Submission Form

Epping to Thornleigh Third Track Proposal. Application number SSI 5132.

Figure 5.6 Cross-section and elevation - New Cheltenham Station concourse building
Note: Indicatively added to future design

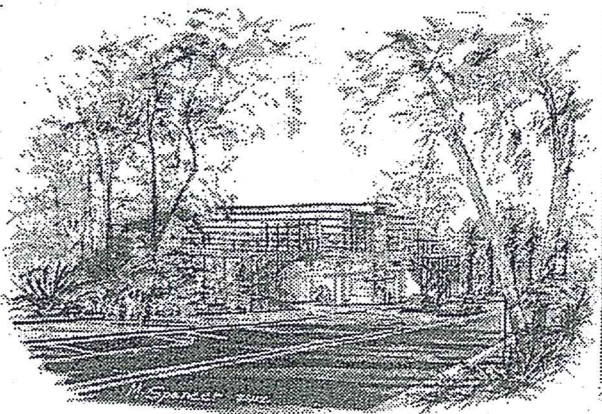
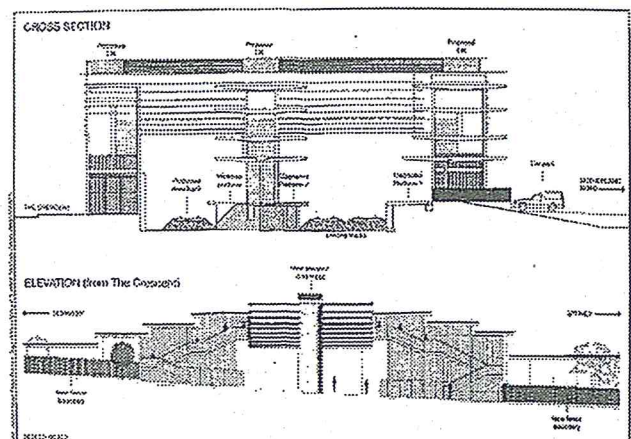
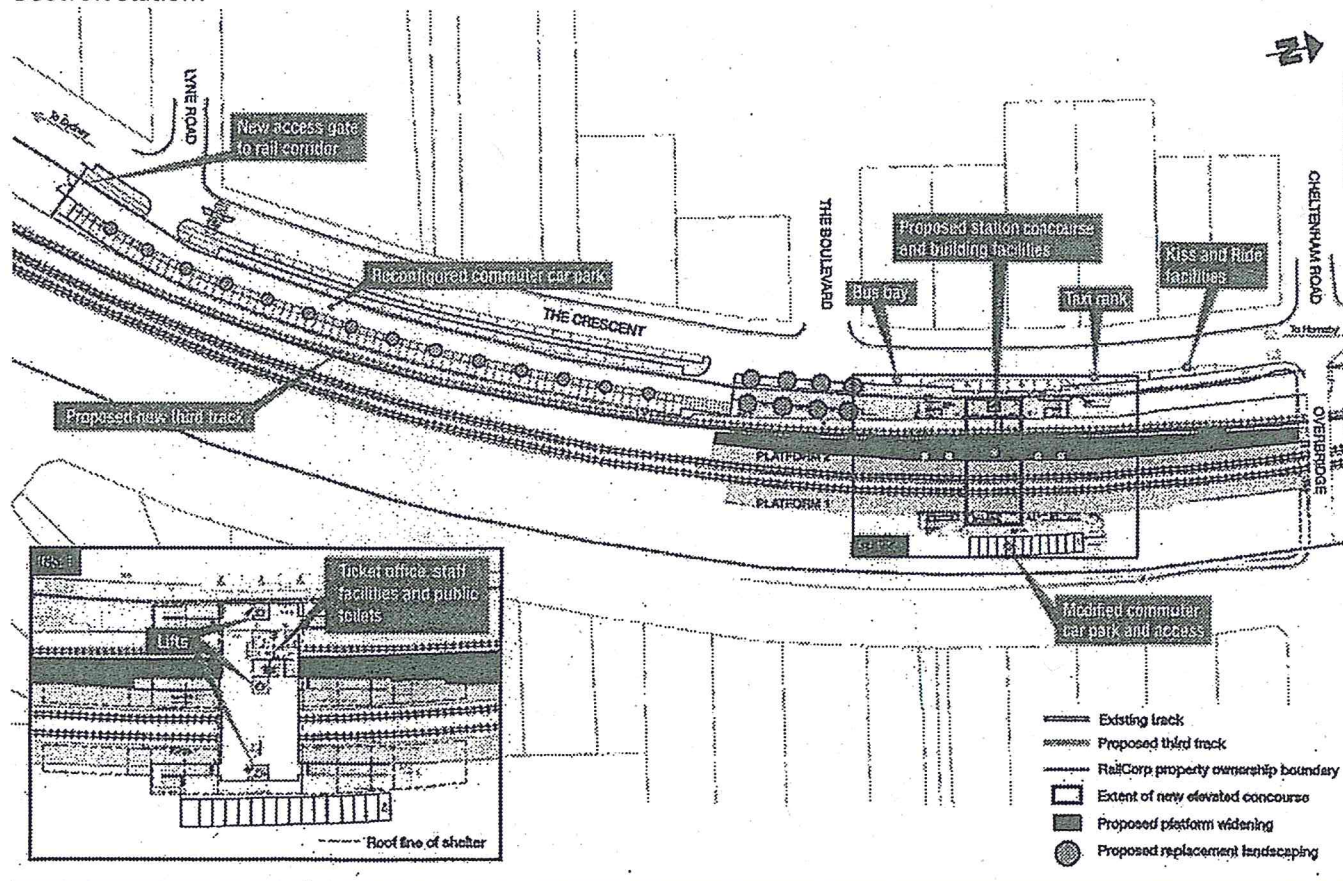
- The proposed redevelopment of Cheltenham Station shows no regard for the HCA. The visual impact of the proposed 13m high glass and steel concourse is totally unacceptable in this HCA.

Concept design drawing of proposed changes to Beecroft Station (Parsons Brinckerhoff 9/3/12). Former side platform shaded in pink.

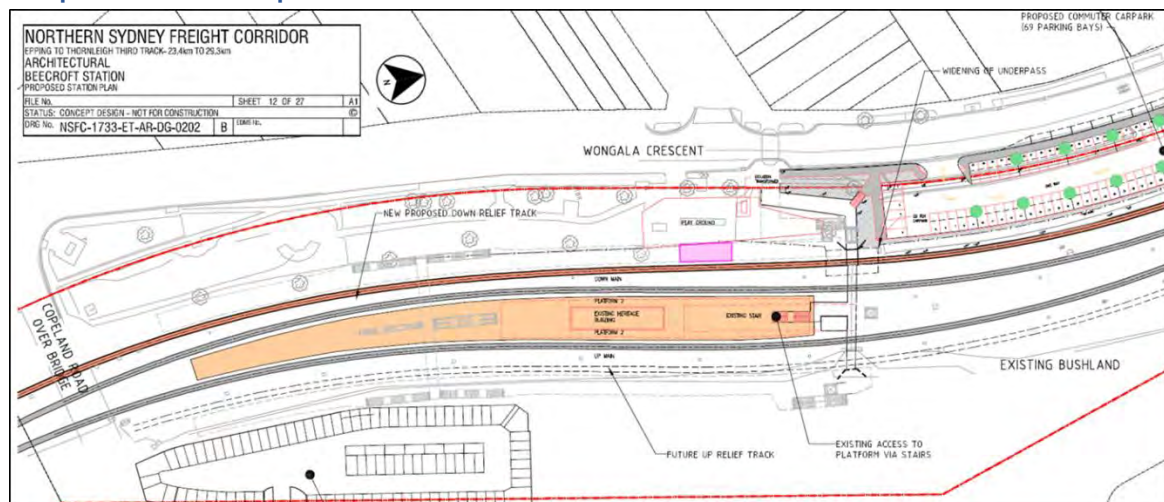
- There has been inadequate assessment of the project's impact on the fabric of the Beecroft Cheltenham Heritage Conservation Area (HCA).
- The plan given for Beecroft Railway station Precinct is vague. The relationship to the trees, playground and original 1895 platform located south of the present station is not shown. A fourth track is shown on the eastern side. The plan does not include urgently needed lifts to allow disabled access at Beecroft Station.
